## **Application by Anglian Water Services Limited for an Order Granting Development Consent for the Cambridge Waste Water Treatment Plant Relocation project**

### **The Examining Authority's third written questions and requests for information (ExQ3)**

**Issued on 21 March 2024**

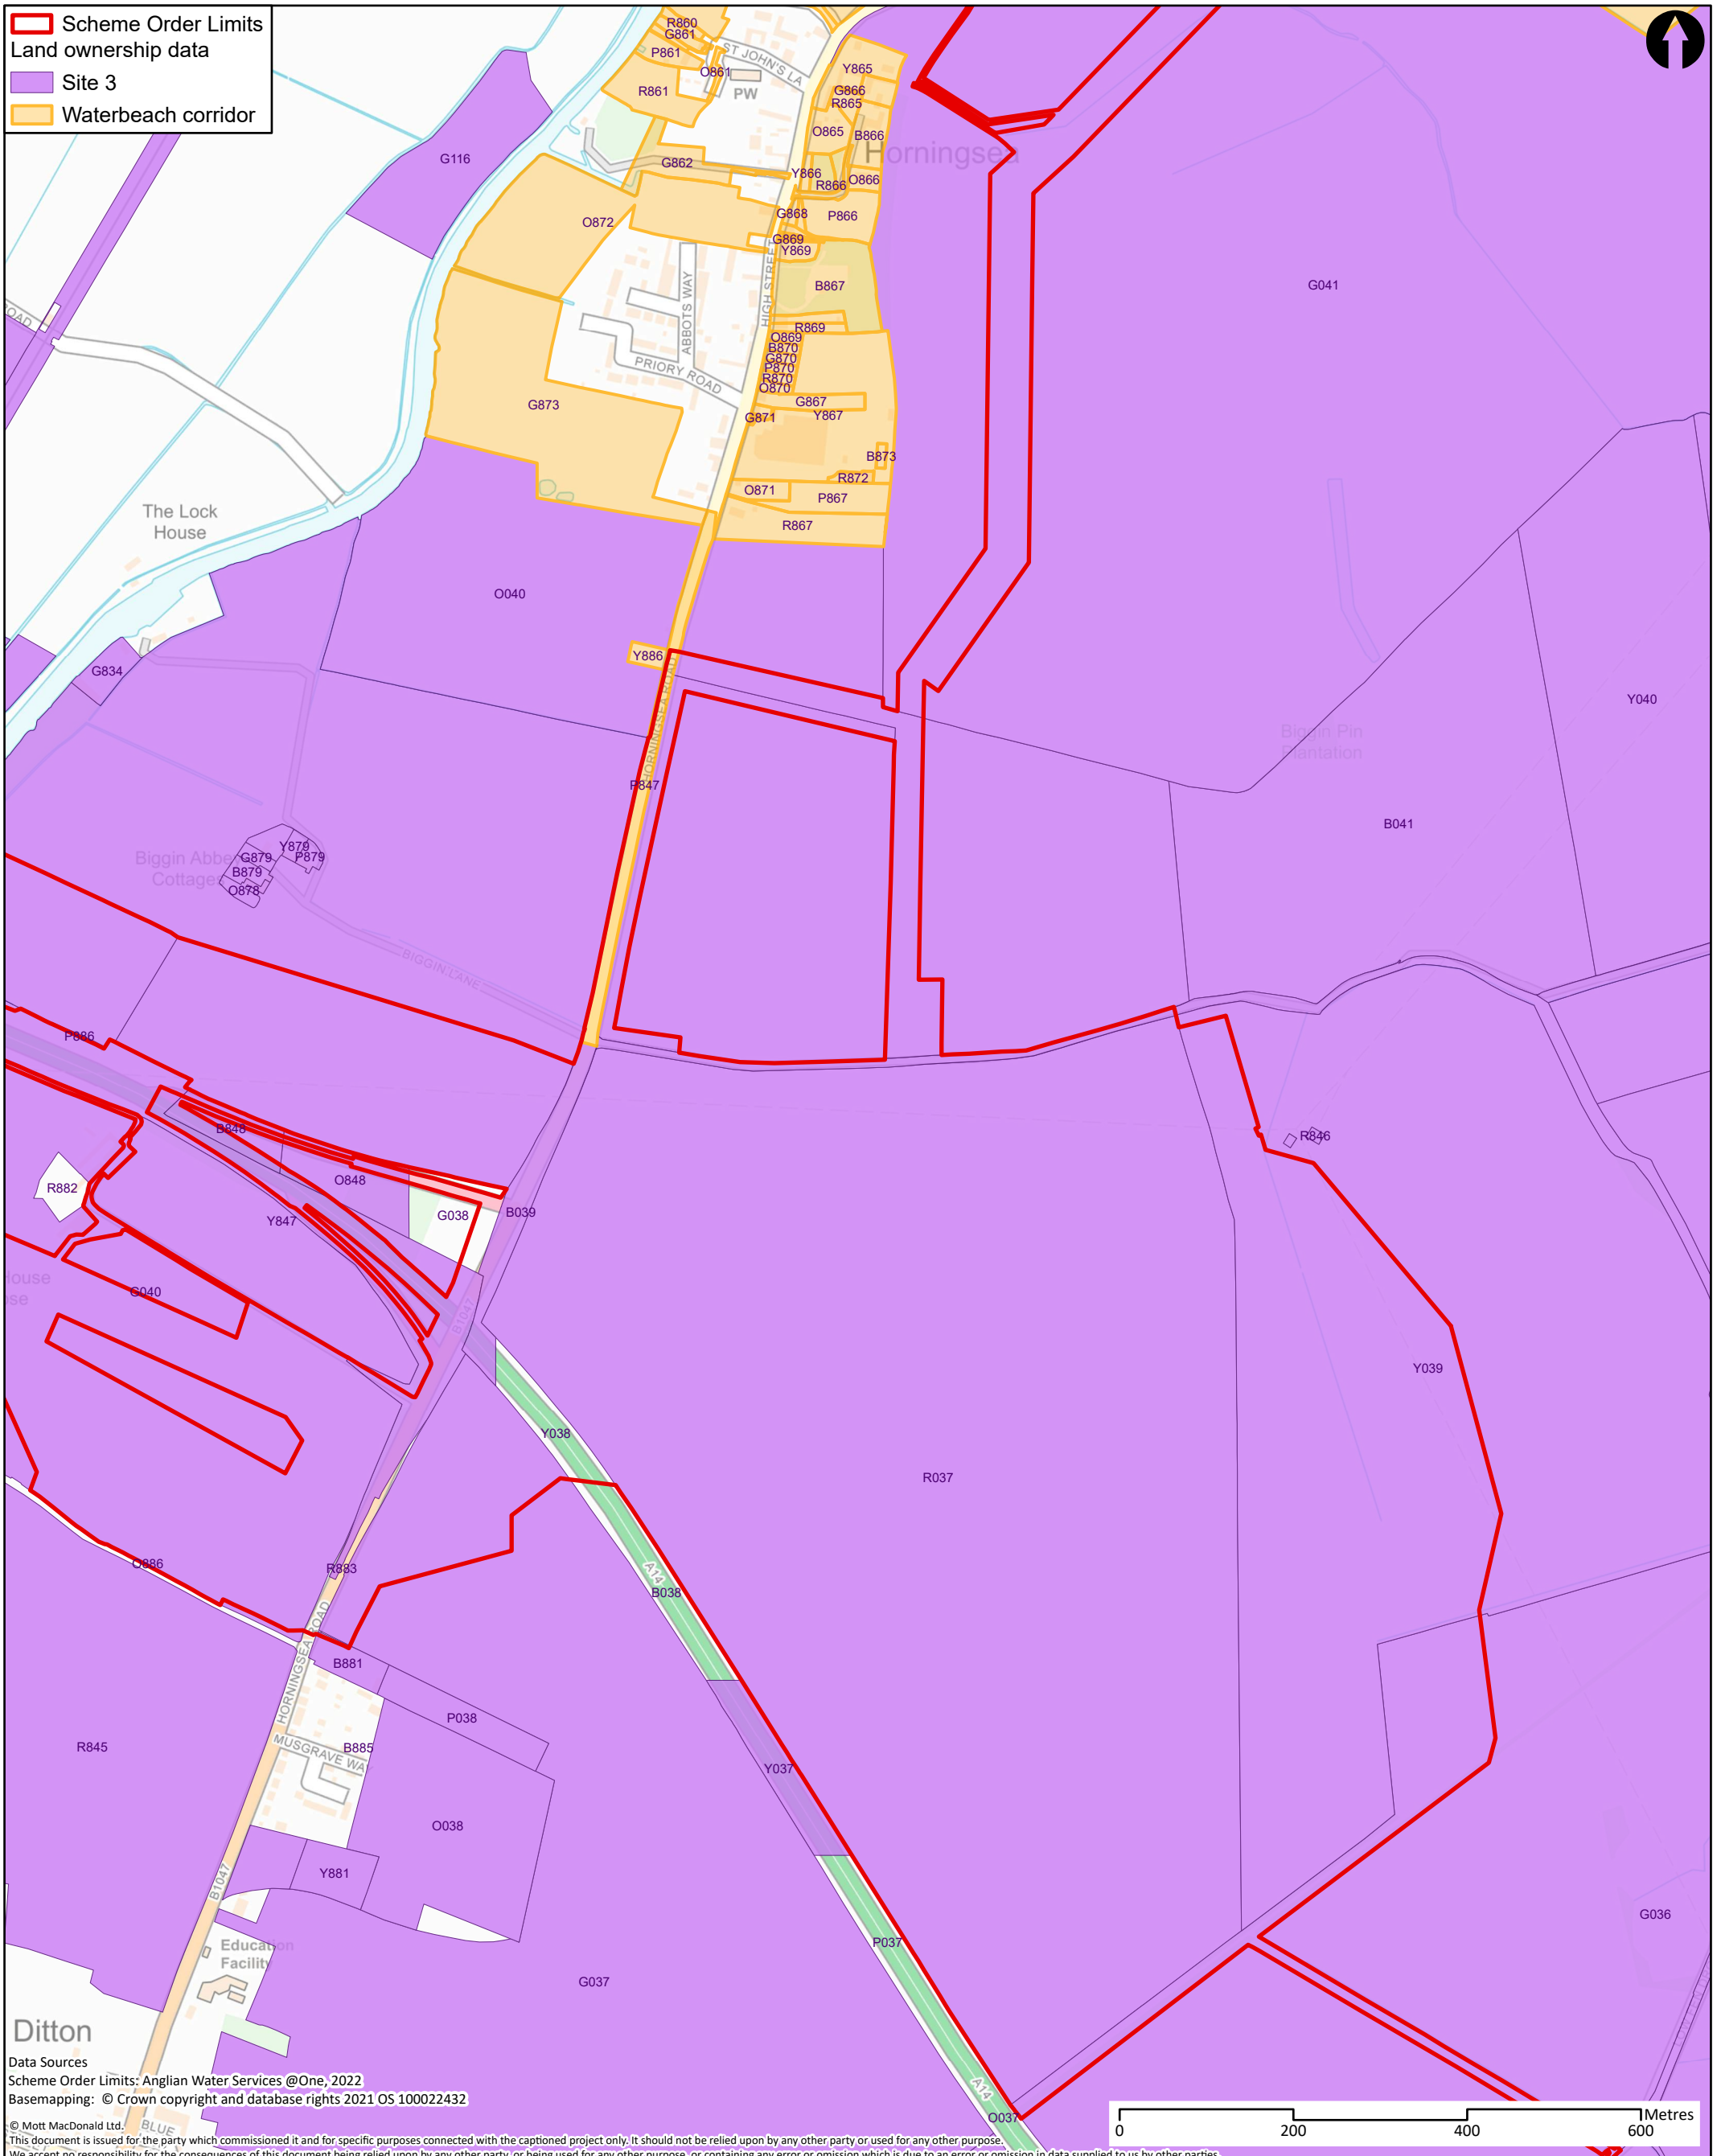
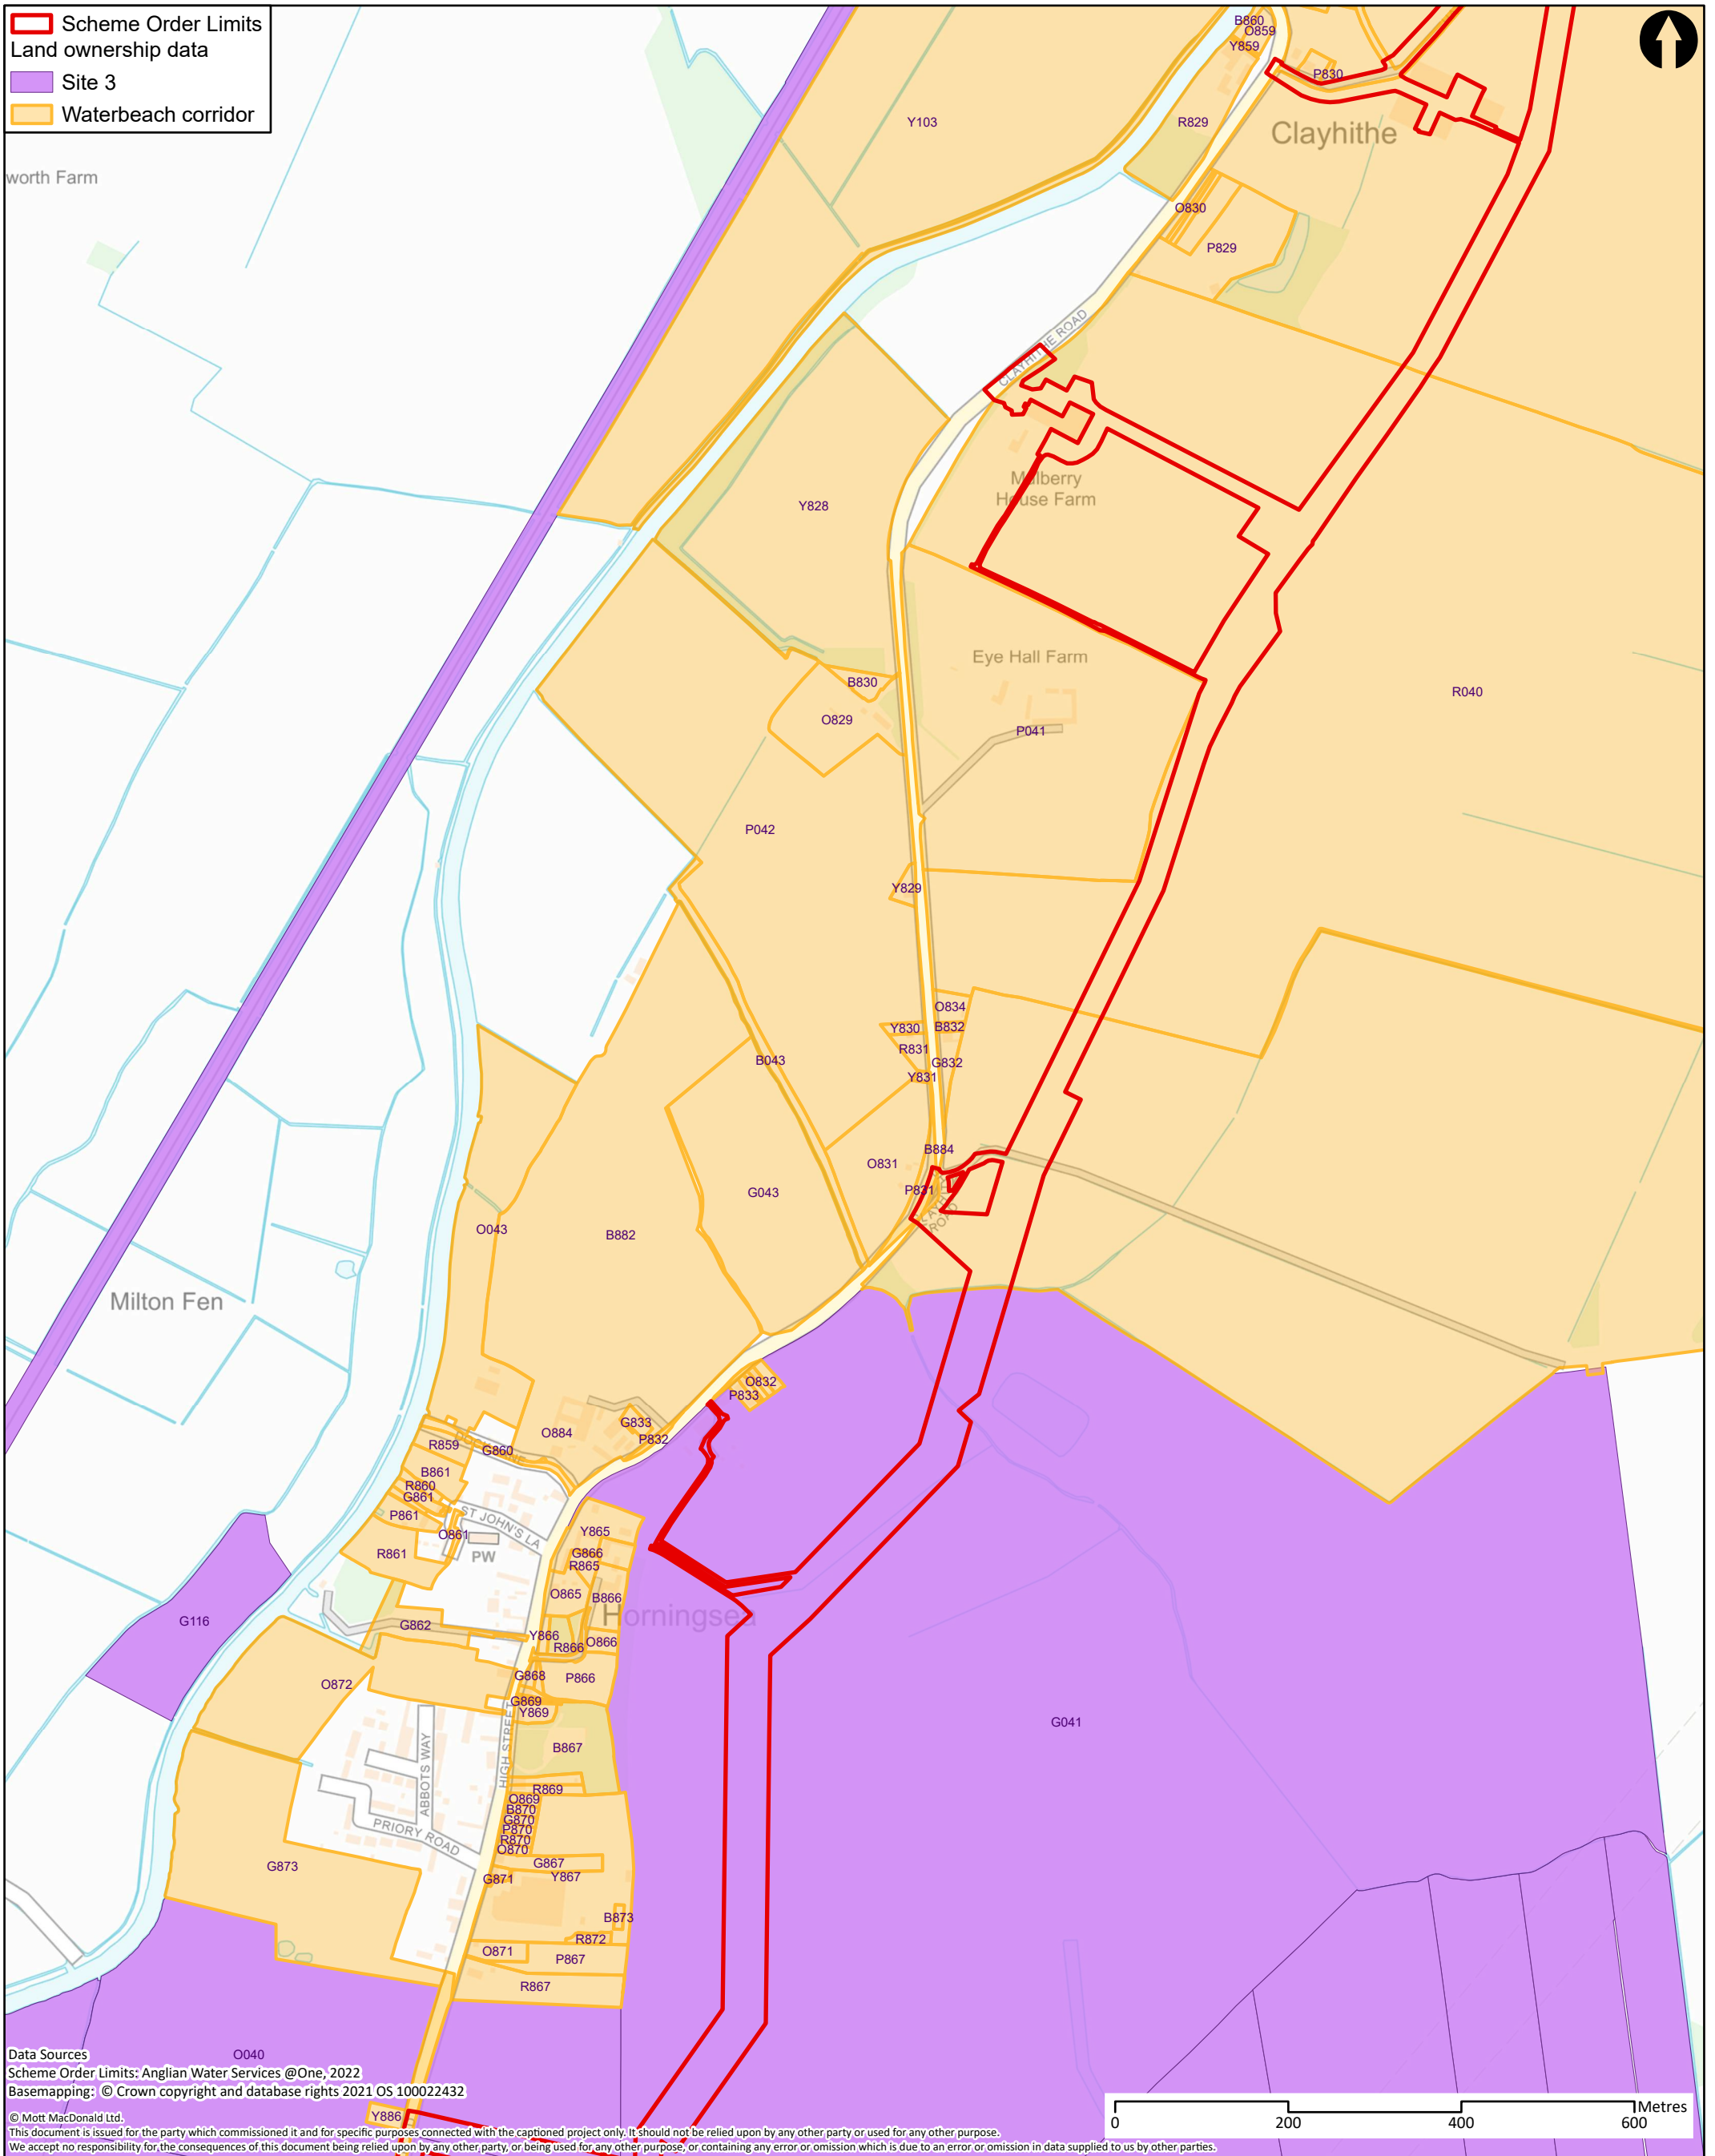
3.1	Applicant	<b>Farm holdings clarification</b> It is unclear from ES Figures 6.11 to 6.14 [AS-049] which farm holdings Plots 036b, 036c, 038c, 042a and 046b relate to. Please clarify / rectify.
<b>4. Air quality</b>		
No further questions at this stage.		
<b>5. Biodiversity</b>
